IMMINGHAM EASTERN RO-RO TERMINAL

Consultation Report Addendum (Appendices K – M)

Document 6.1.1

PINS Reference – TR030007

Figure 2.4: Port Layout incorporating impact protection at the north western end of IOT 6/8 finger pier

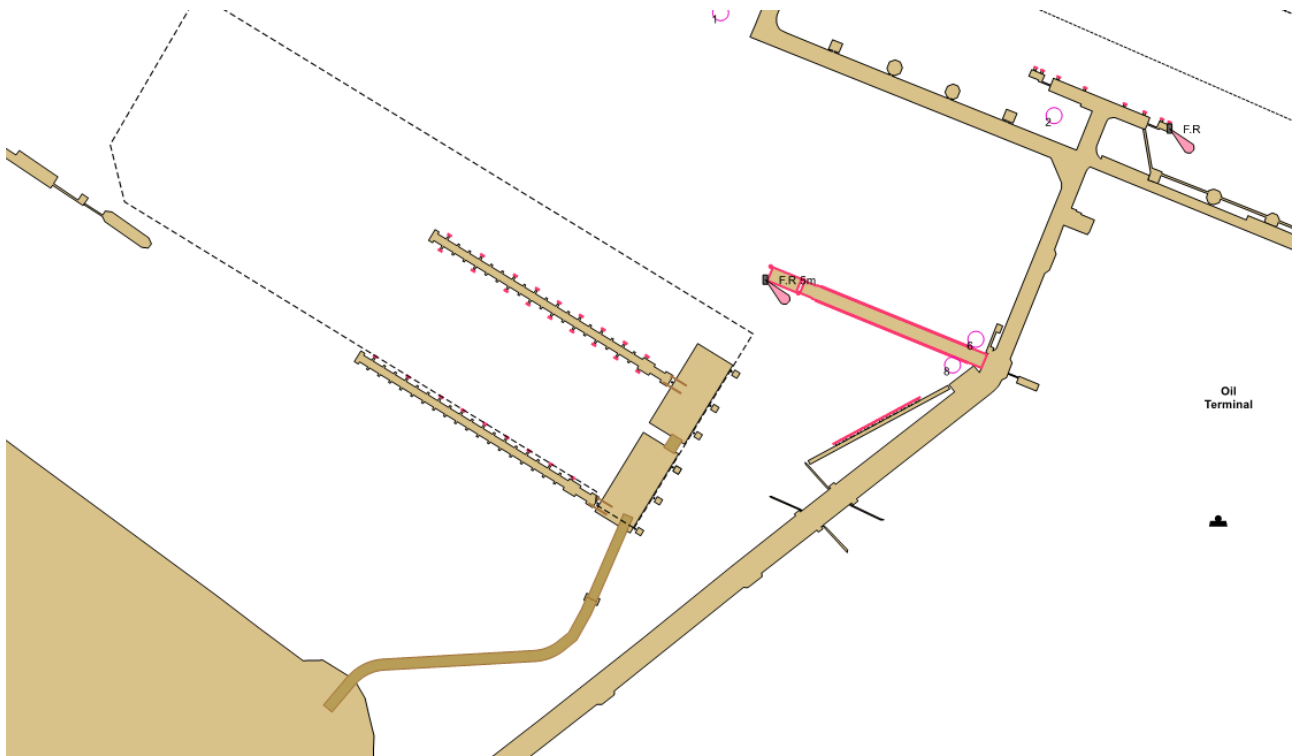
DFDS (CA 35)	Change Application Consultation 17.11.23	The impact protection added to the end of the IOT Finger Pier may itself have an impact on navigation as it effectively makes the pier longer, not only on vessels using the IERRT	Navigation simulations of the Proposed Changes have been undertaken and are provided at Application Document Reference number 10.3.9. The outcomes of this exercise indicate that tankers and barges arriving or departing at IOT finger pier berths, as well as

but also the south side of the finger pier, and further navigational simulations of such movements should be carried out with the proposed impact protection in place.	vessels arriving at IERRT, can be done safely with Proposed Change 4 in place (see NRA Addendum).
DFDS (CA 35)	Change Application Consultation 17.11.23	<p>With respect to Proposed Change 4, DFDS understand that the Applicant will, in lieu of installing adequate impact protection, require vessels arriving at Berth 1 on the ebb tide to have a mandatory bow tug to protect the IOT Finger Pier in the event of an issue.</p> <p>It is DFDS' opinion that such a measure is not a suitable replacement for, nor as reliable as, physical protection measures. Physical impact protection does not suffer machinery breakdown, lack of availability, towline issues such as parting or fouling of the towline, are not affected by wind nor tide, nor are reliant on any human input.</p>	<p>The comments from DFDS are noted.</p> <p>The risks have been re-assessed in light of Proposed Change 4 in the NRA Addendum at Annex C of this ESA.</p> <p>The outcomes of this assessment remain the same as concluded in the original NRA, in that impact protection measures have been considered as an Applied Control and will only be provided as part of the 'project specific adaptive procedures' if required.</p> <p>The need for physical impact protection will be determined by the SHA and may be introduced in the future. The effect of installing the impact protection measures as now covered by Change 4 have also been assessed.</p>
